## KITTITAS COUNTY COMMUNITY DEVELOPMENT SERVICES

February 22, 2016

RE: Strole Agriculture Short Plat, SP-15-00009

**STROLE AG SHORT PLAT SS - XX-XX
PREPARED FOR
JEFF STROLE**
A PORTION OF THE W 1/2 OF SECTION 35
TOWNSHIP 19 N., RANGE 18 E., W.M.

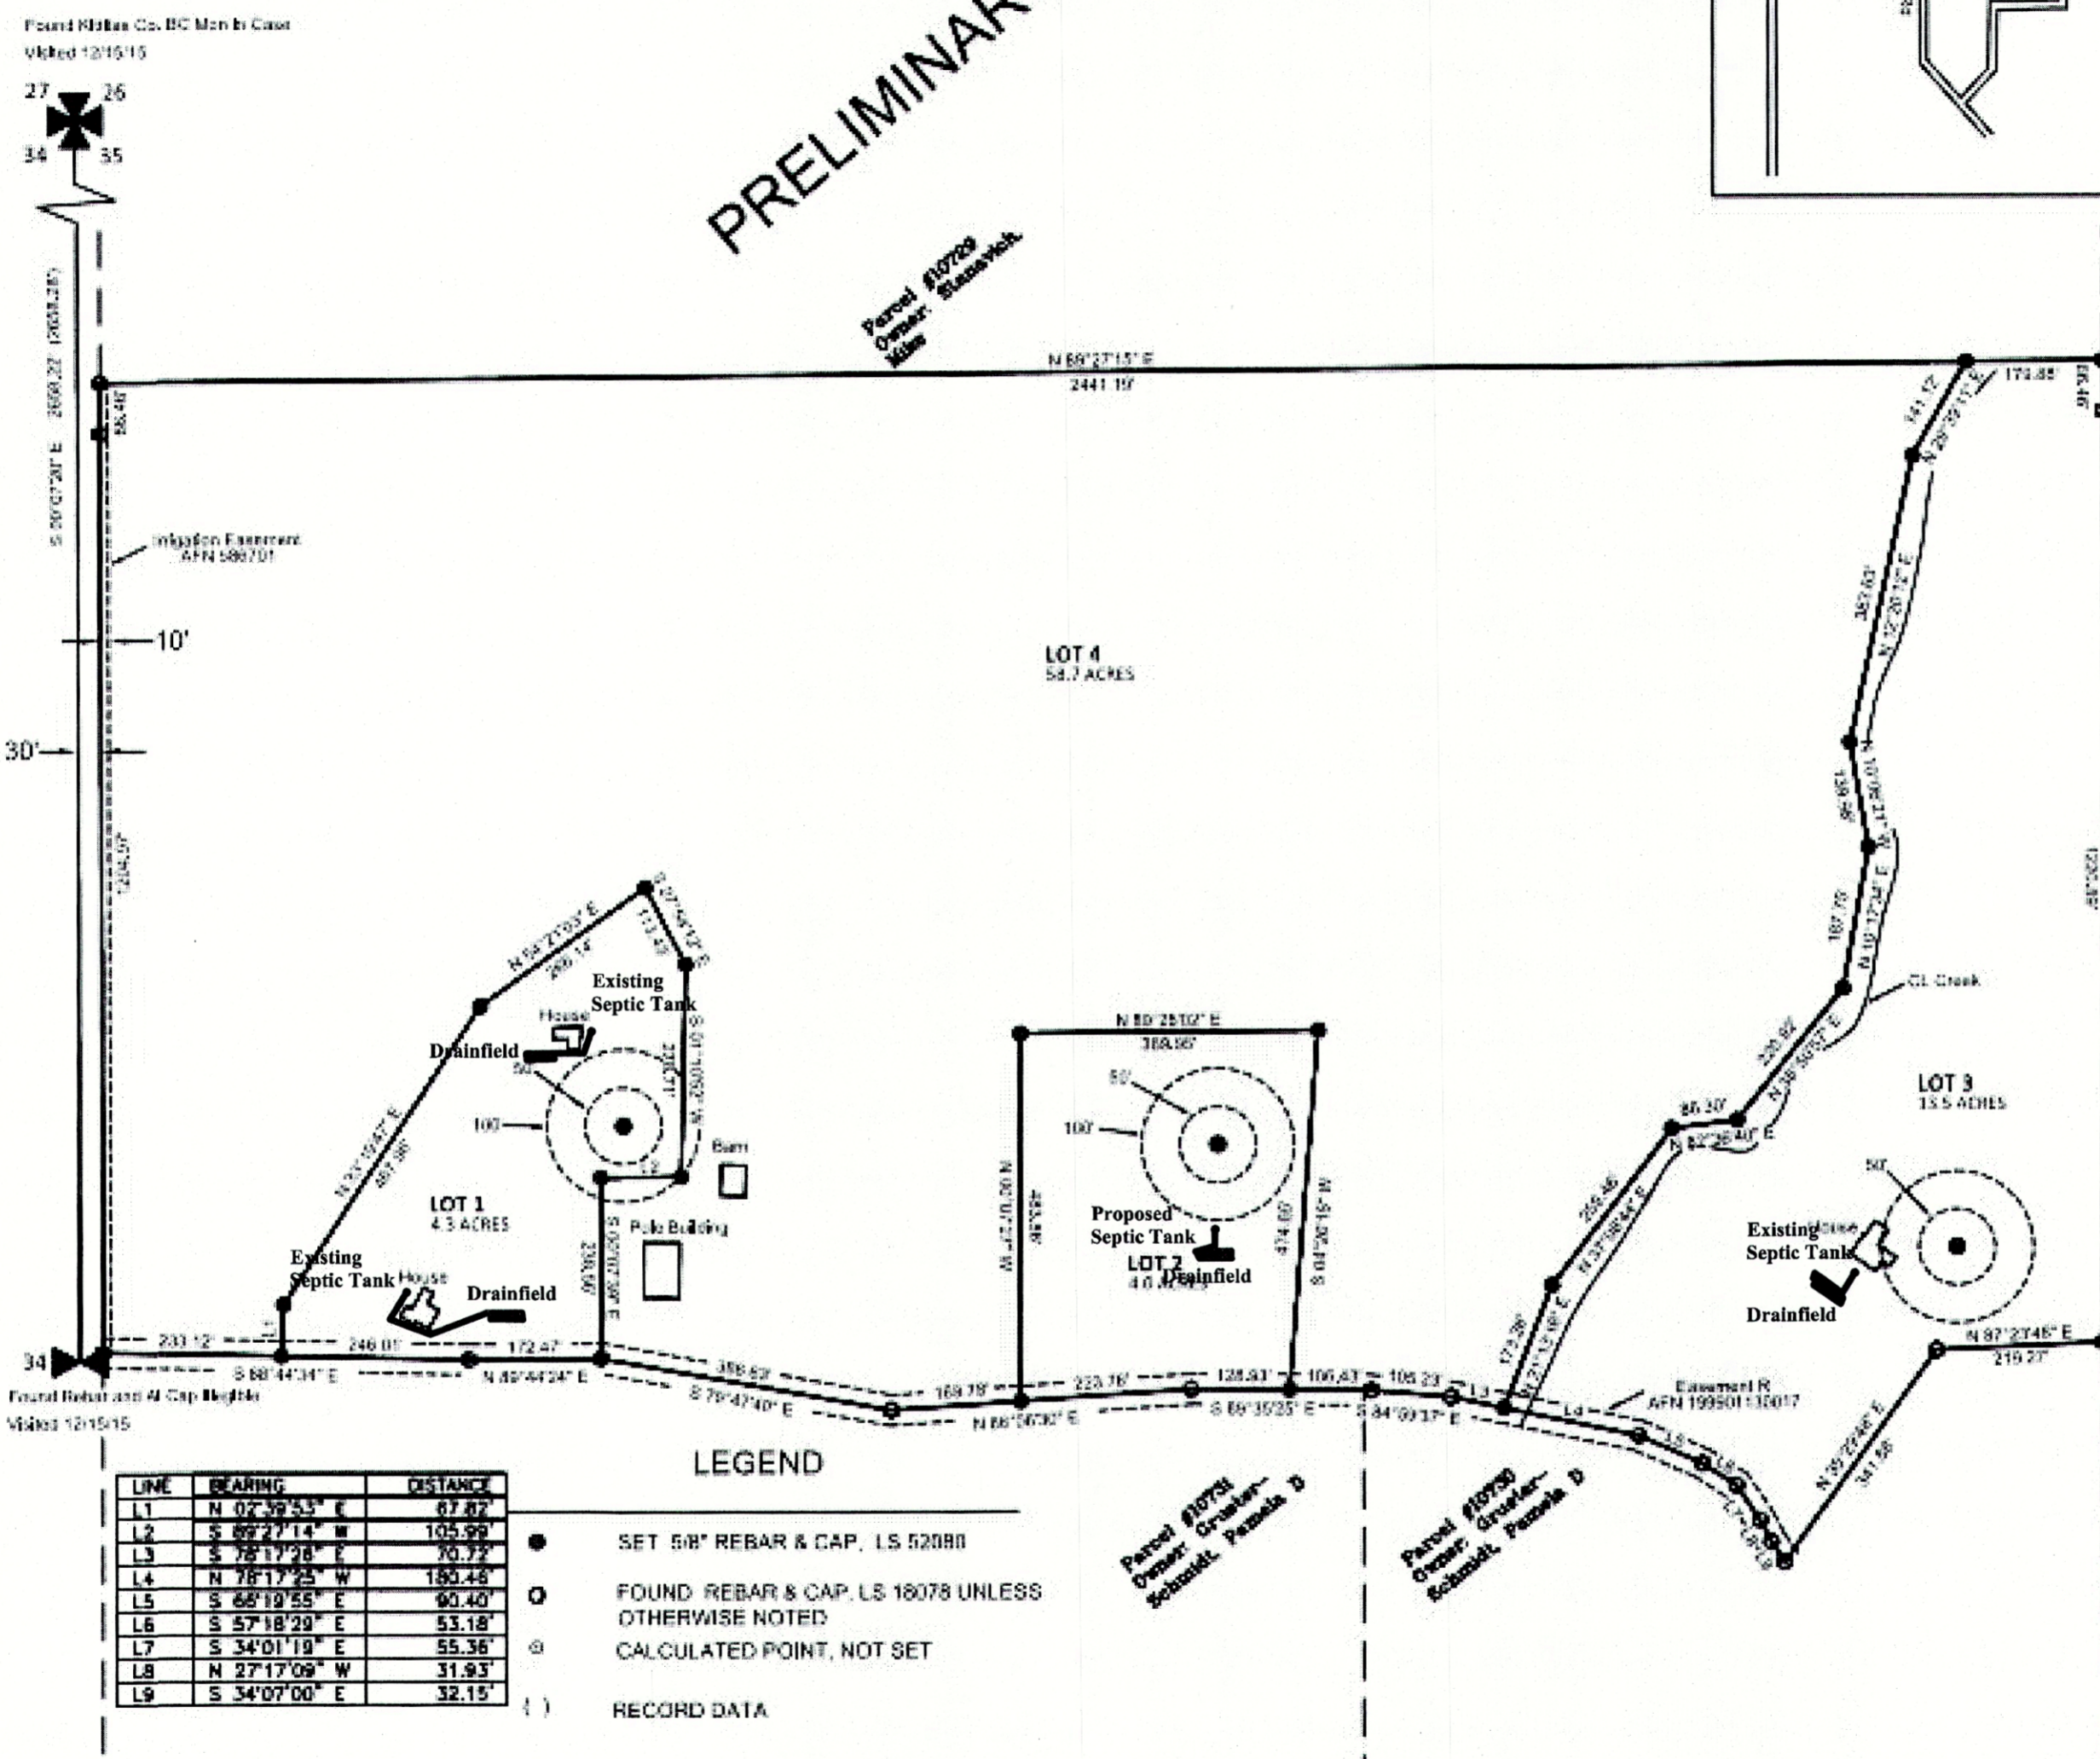
During review staff has determined that a revised site plan showing all septic's and drain fields is required in order to continue review. Additional information must be submitted to CDS within 180 days :
